UNIVERSITY OF PORTSMOUTH

LANGSTONE CAMPUS, FURZE LANE, PORTSMOUTH, PO4 8LW

WRITTEN REPRESENTATION (6th OCTOBER 2020)

2. This WR outlines the detailed objections that UoP have to the Development Consent Order application for the AQUIND Interconnector (“the Proposed Development”), submitted by AQUIND Limited (“the Applicant”) to the Planning Inspectorate on 14 November 2019 for recommendation to the relevant Secretary of State.

AQUIND Interconnector Sheet 9

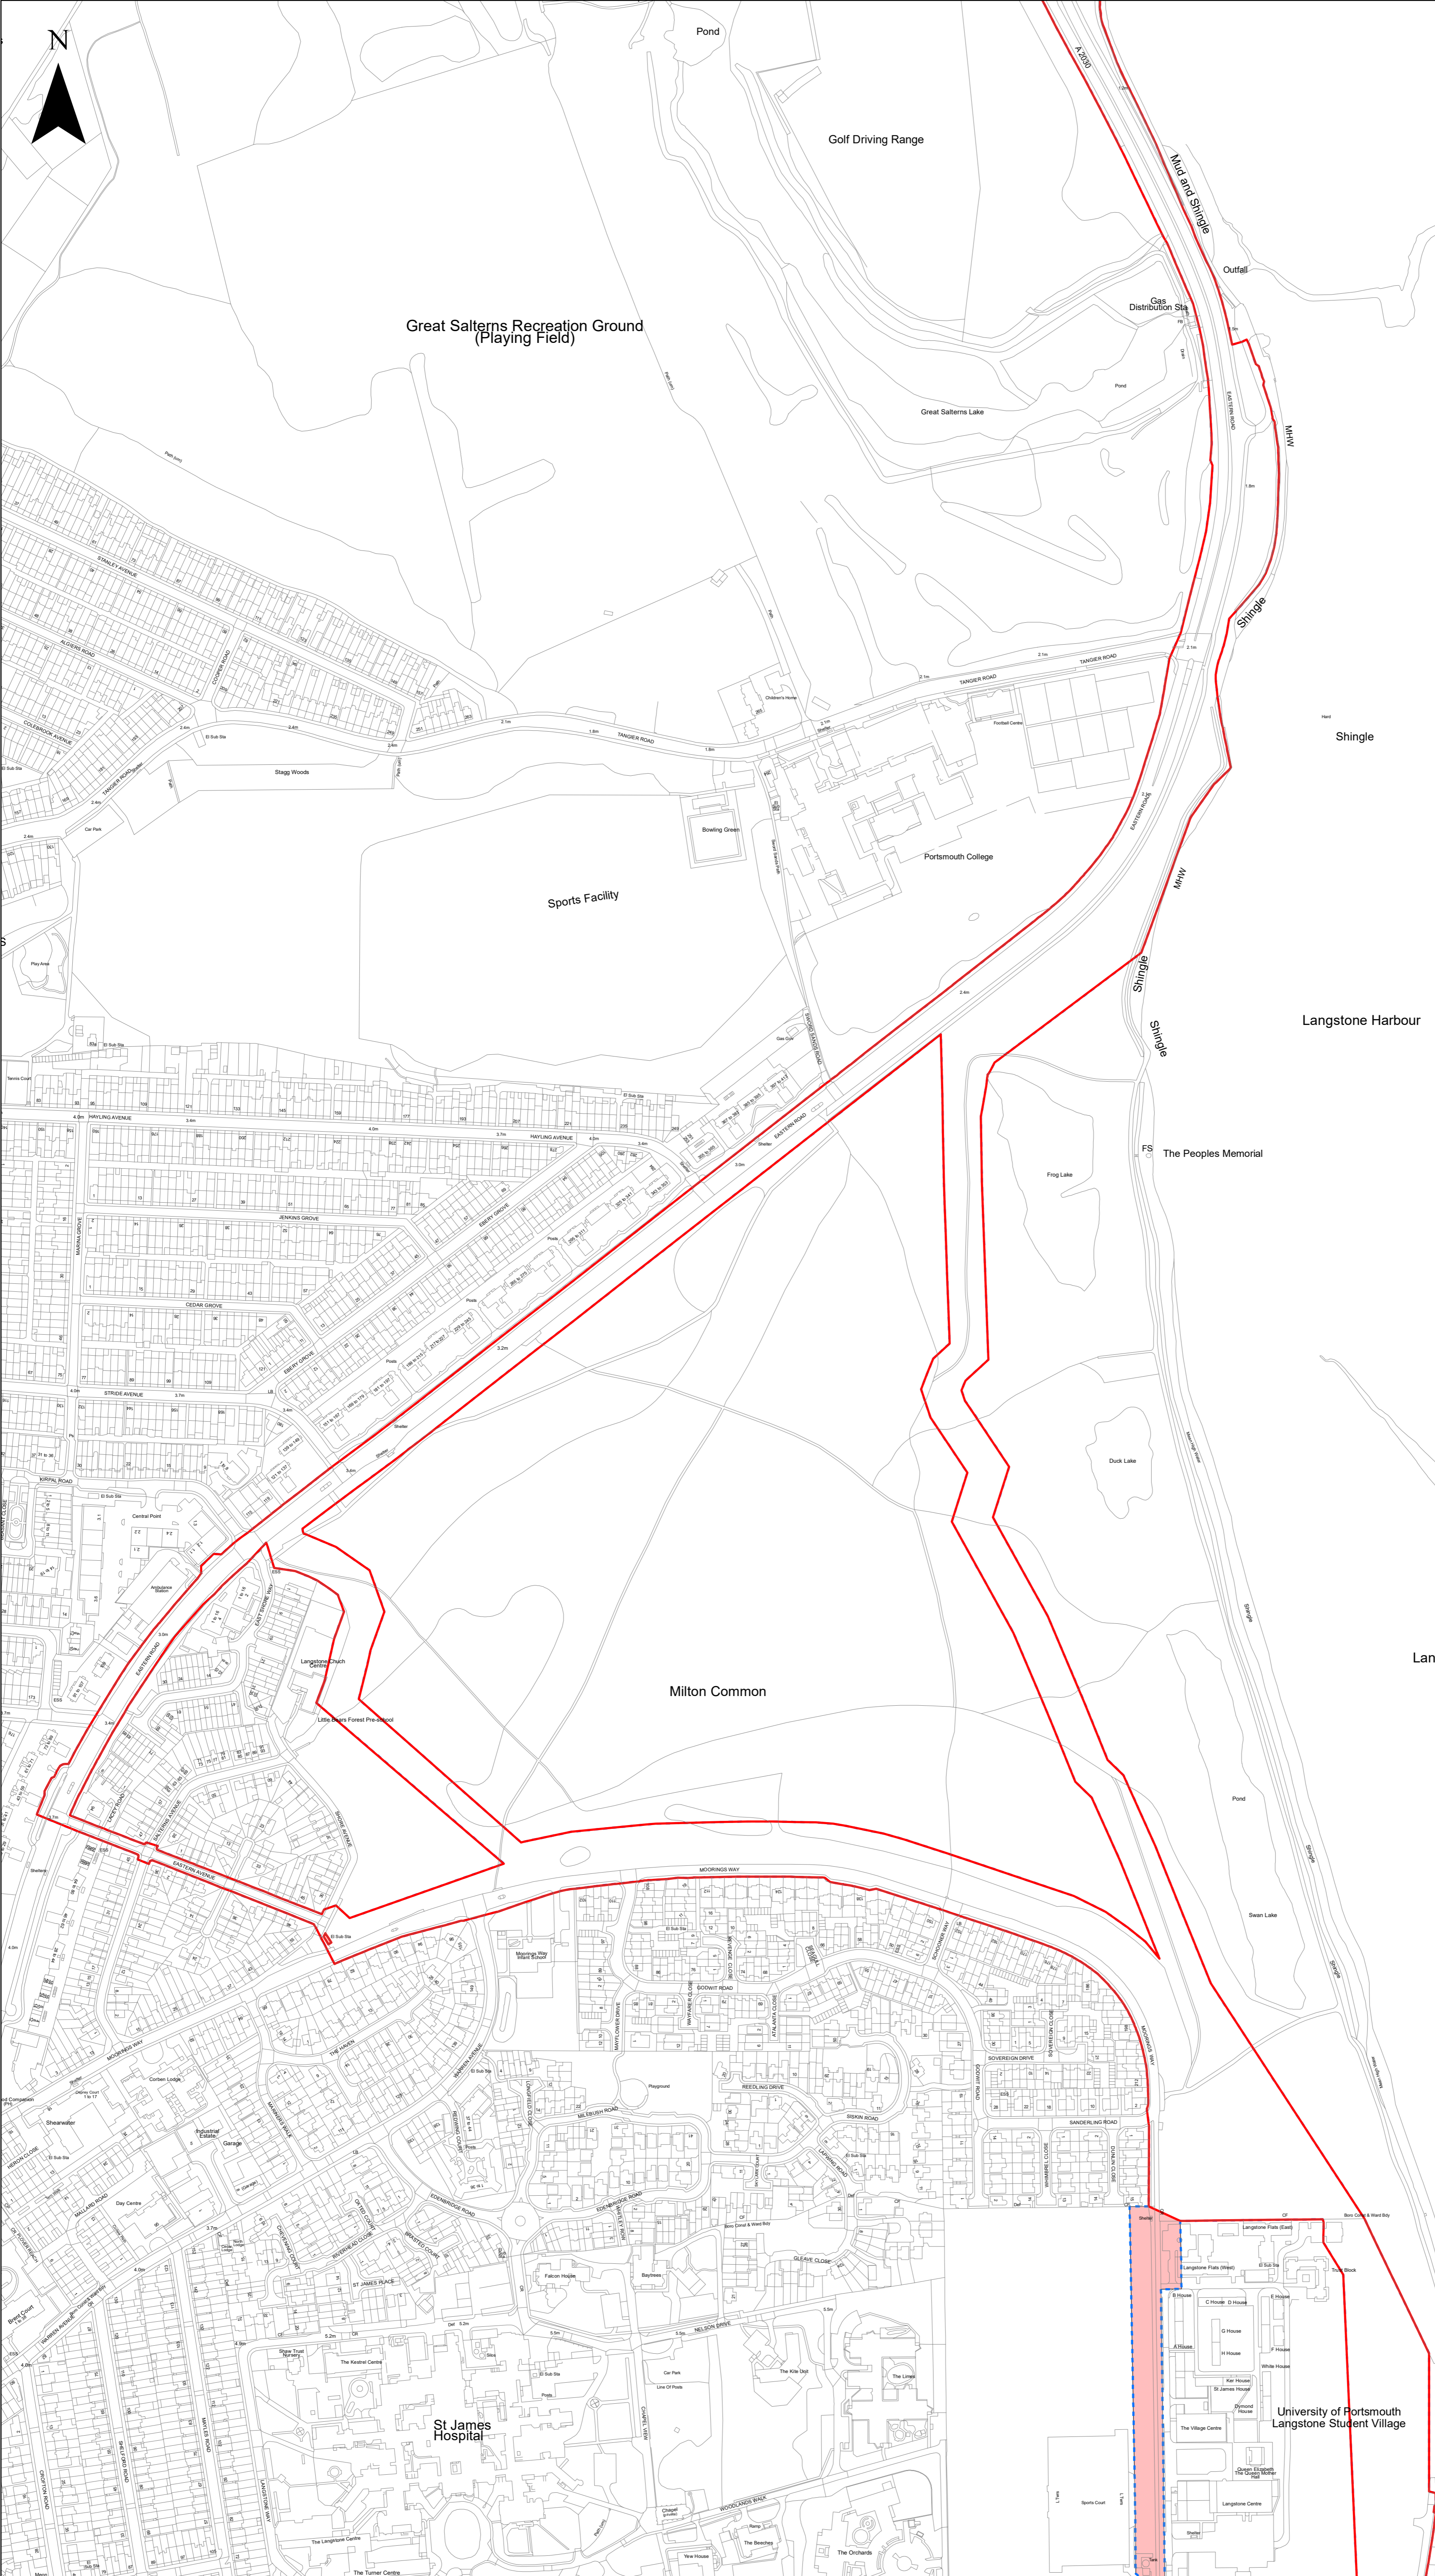
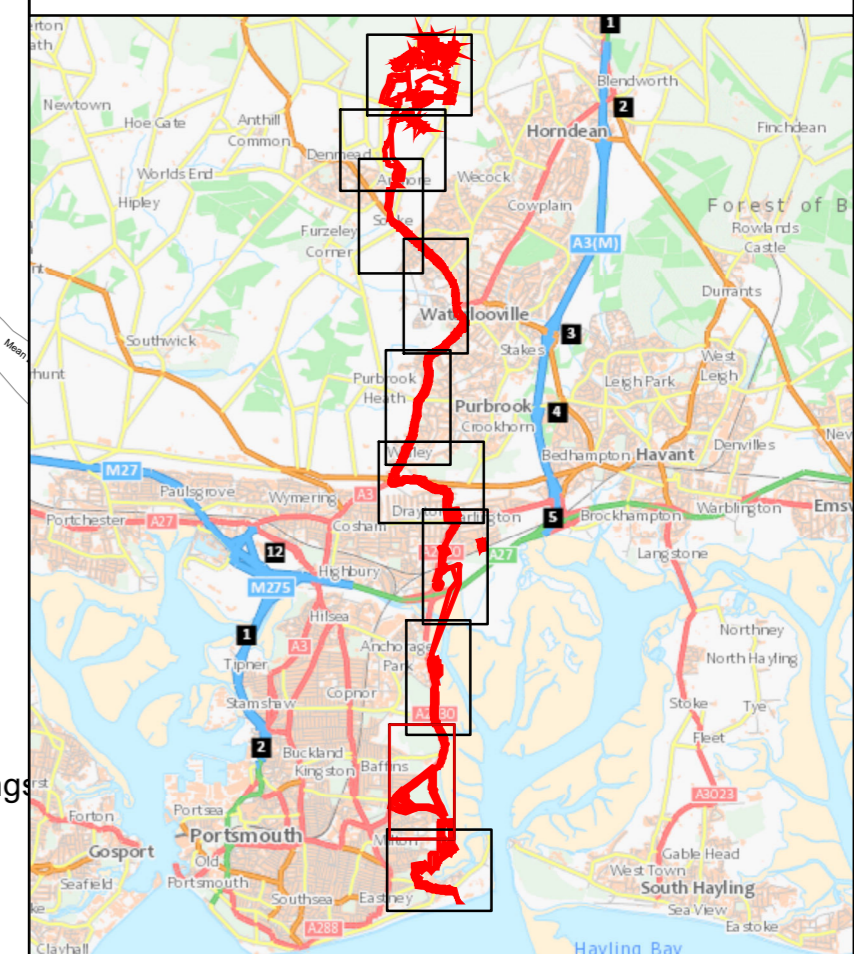
23. The Order Limits and Land Plans (Sheet 9 and 10/10) identify the following affecting UoP's land:
- (i) New Landscaping Rights on the western boundary of the Campus site (Refs: 9-21 and 9.24);

- (ii) Temporary use of land in the north-western corner of the Campus site (Refs 9.22-9.23);
 - (iii) New Landscaping Rights alongside the Langstone Sports Centre boundary (Ref: 9-25); and

- (iv) New Connection Works Rights on the eastern edge of the Campus site on existing playing pitch land (Ref: 9-26).
24. New Connection Works Rights are also noted along Furze Lane (Ref: 9-27). This is adopted Highway but offers the only form of access to the Campus and Sports Centre sites.

25. It is not clear or explained in the Application submission why two north-south connection rights areas have been identified. Both have significant impacts on UoP land and operations.

- Why the land is required given the north and south onshore cable corridor options.
 - Why two Connection Works Rights are necessary on a north-south route in this area. The options analysis in the Environmental Statement (see Volume 1, Chapter 2, paragraph 2.6.6.21) identifies the two options but there is no explanation of why the two remain in the Order.

- If only one route is required does that mean the other is not? The rationale for two routes requires further explanation as it is not outlined in the Alternatives assessment in the submitted Environmental Statement.

- The programme of works and the approximate timing in the calendar and academic year.
 - Whether the works also involve the complete or partial removal of access to Furze Lane and the Langstone Sports Centre during that period. In the absence of any explanation from the applicant it has to be assumed they will.

- What is the extent of works required on the playing fields and how does this relate to the extent of the Rights Land identified?
 - Can the restoration activity to the playing fields be completed within the 8 week period?

- What allowance within the programme has been made for damage that may occur to the pitches? Once allowance is made for planting season constraints this is very likely to take this programme beyond 8 weeks whilst the earth is remodelled and grass re-laid.

- What future maintenance works will be needed on the Rights land and what specific areas will require permanent access. Depending on the extent access/maintenance zones this

- What maintenance and management arrangements are proposed for the new landscaping areas?
- Will there be easements on the Connection Works Rights land which then impact upon the ability to develop the Campus site and future land use options such as residential and associated amenity space?
- What consideration is given to the protected TPO trees along Furze Lane?
- What consideration is given to the bus route and highways interruption caused by works to Furze Lane?
- The high voltage cable environment and the impact this could have on the essential radio link to the Home Office Licenced research facility at IMS Eastney.

46. UoP recommends that consideration is given to removing the Furze Lane route entirely. The land required to the east of the Campus should be moved further east to along the boundary of UoP's ownership. This would remove the significant playing pitch revenue and operational conflicts on the Sports Centre and the potential impact on the future development potential of the Campus site.
